M60/M62/M66 Simister Island Interchange

TR010064

7.16 APPLICANT'S RESPONSE TO ISH1 SUPPLEMENTARY AGENDA

Version	Date	Status of Version
P01	24 September 2024	Deadline 1

Reproduced by permission of Ordnance Survey on behalf of HMSO ©
 Crown copyright and database right 2024. All rights reserved. Ordnance
 Survey Licence number 100030649.

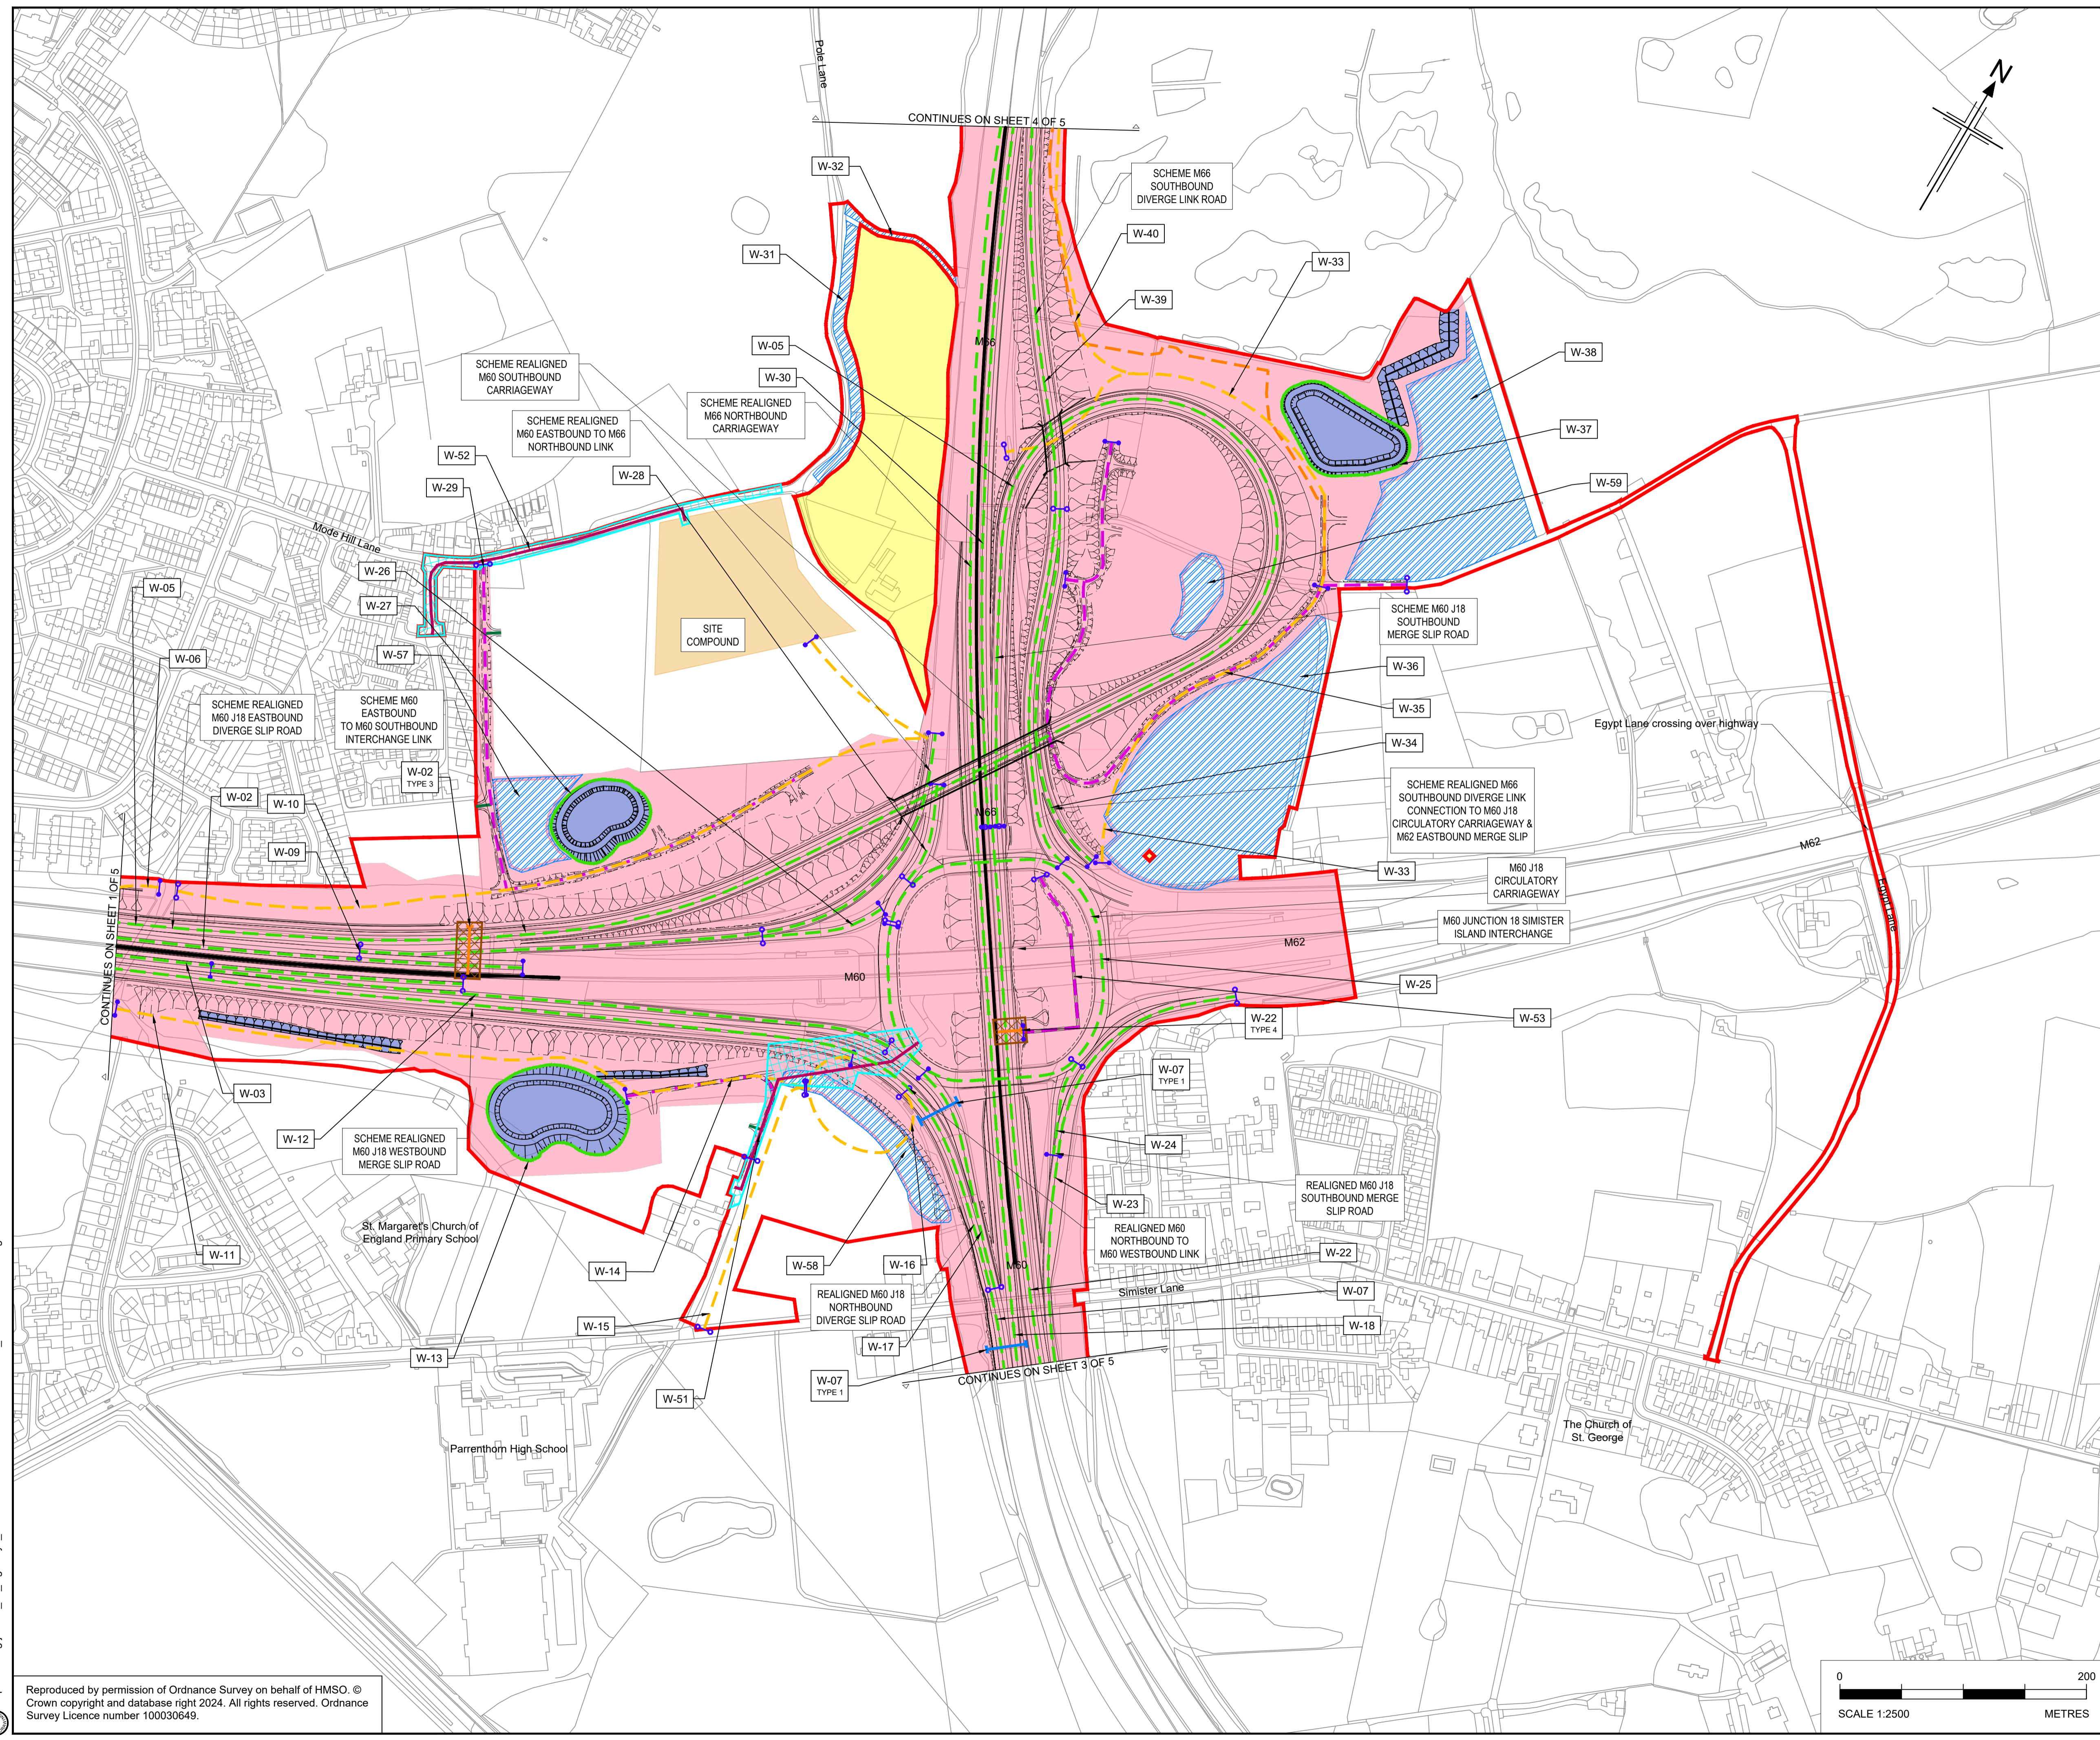
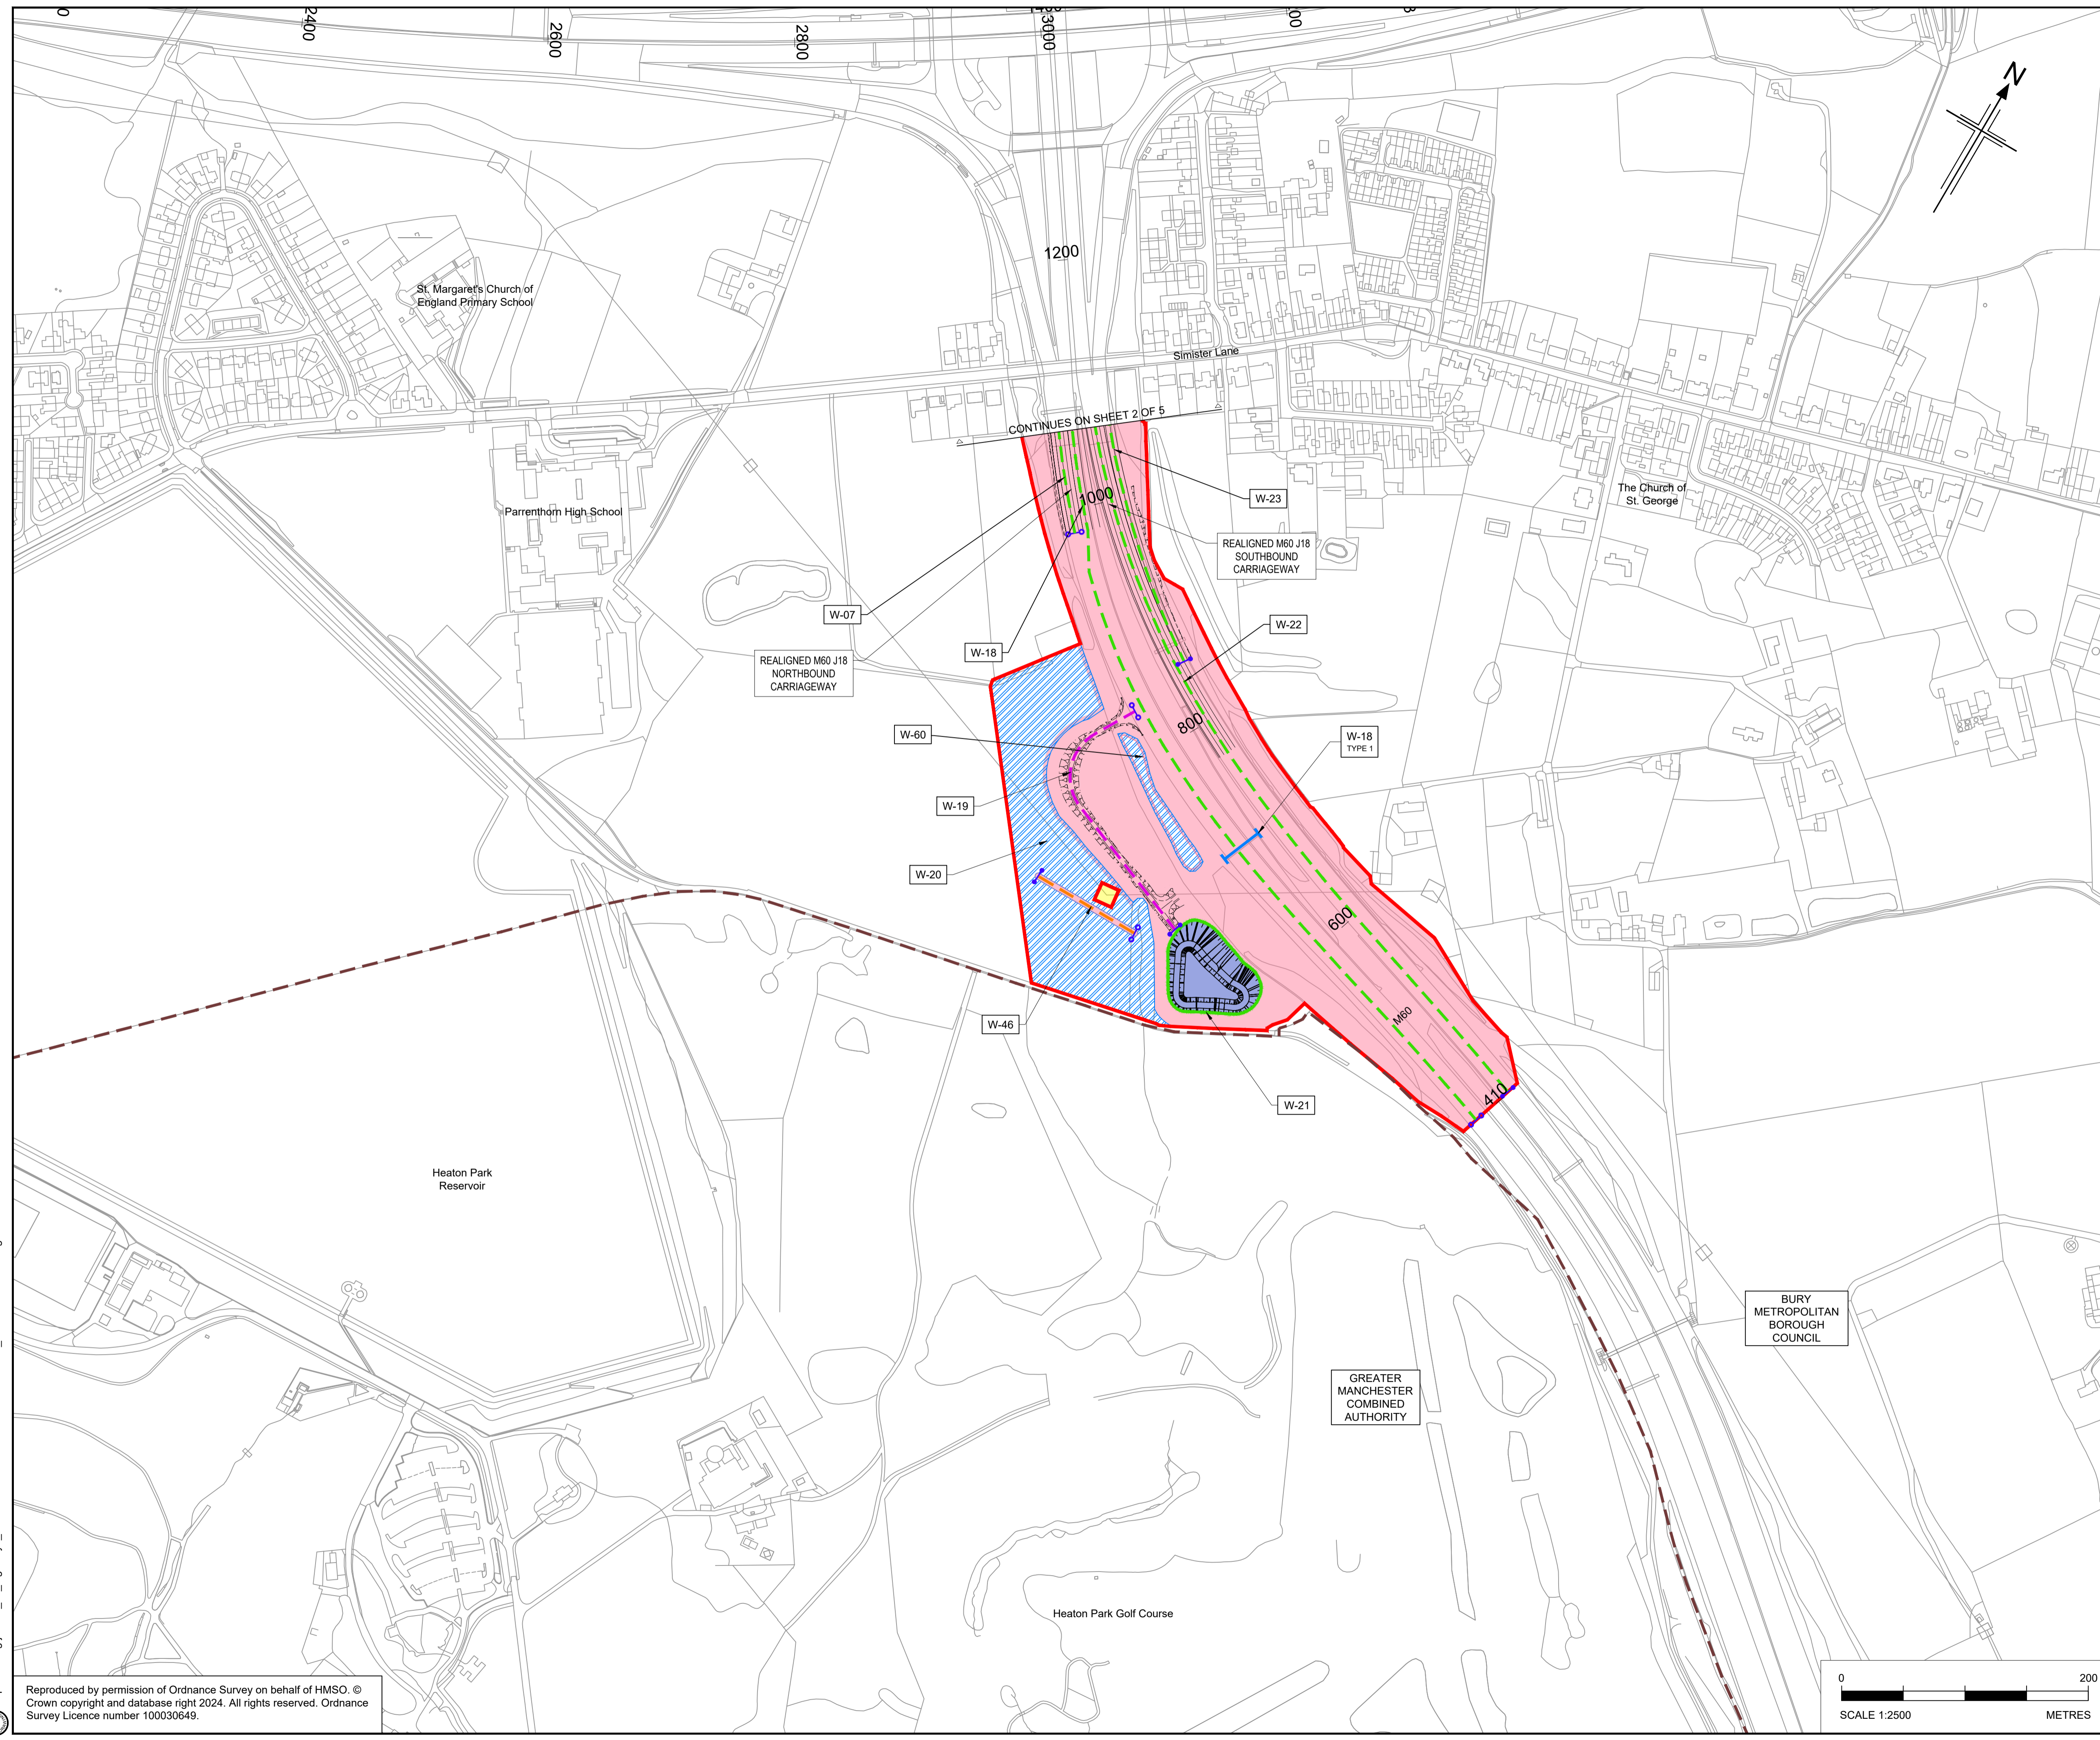
Part 2 – Principal Powers				
ISH1.A.13	Clarification	Applicant	Article 6(1)(a) – Limits of deviation The works plans [AS-006] referred to in paragraph (1)(a) identifies in the 'Key' to each of the plans limits of deviation applying to 'Highway Work', 'Scheme Gantry' and 'Utility Diversion'. Please clarify, what would 'Highway Works' include?	'Highway Works' includes all of the works comprising the authorised development except gantries and utilities. For instance, it would include carriageway, structures, environmental mitigation features (ponds etc.) and temporary works (haul routes etc.). The limits of deviation for gantries and utilities have their own limits of deviation because it is often requested and has become common practice.
